Our Ref: BE/92/21/DOC

Part 5 of the Town & Country Planning (Development Management Procedure) Order 2015
Approval of details reserved by condition imposed under ref. BE/135/18/PL relating to
Condition No. 15 (full permission) regarding the submission of As-Built Drawings and a
Completion Report prepared by an independent engineer

Land at Salt Box, West of Shripney Road, Bognor Regis

Arun District Council have decided to **REFUSE details reserved by this condition**

PLAN

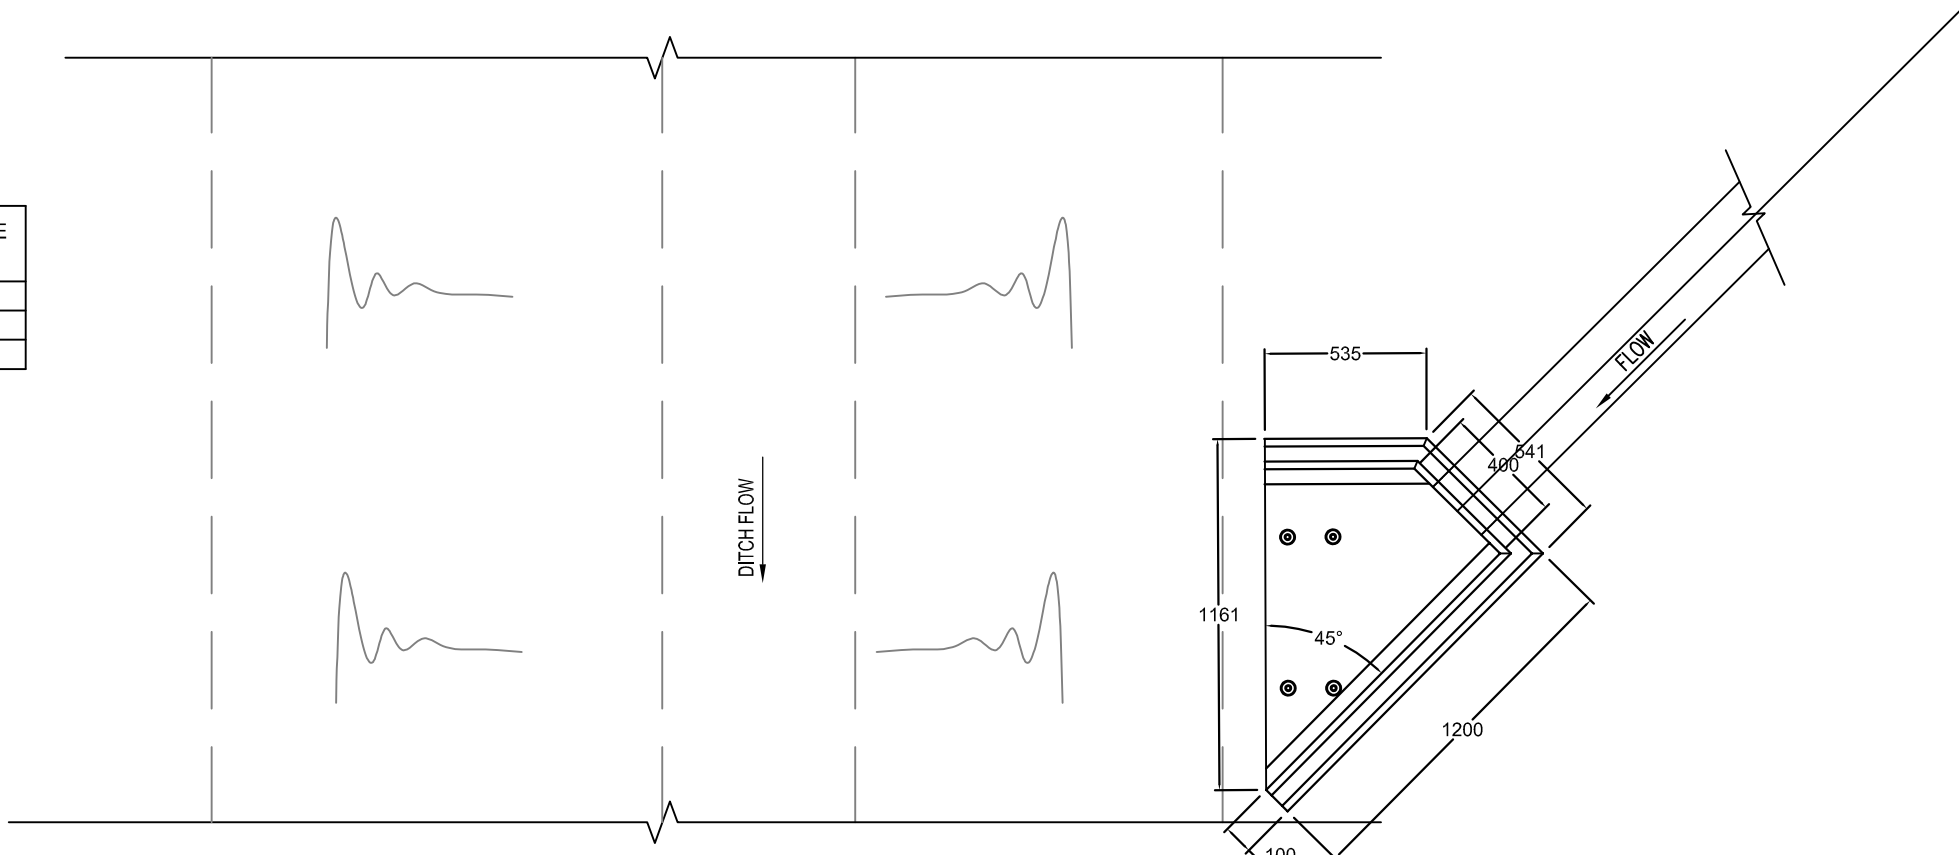
The headwall angles have been altered since approval. No evidence has been submitted to prove that the relevant consents (FRAP and Land Drainage Consent) apply to the revised headwalls.
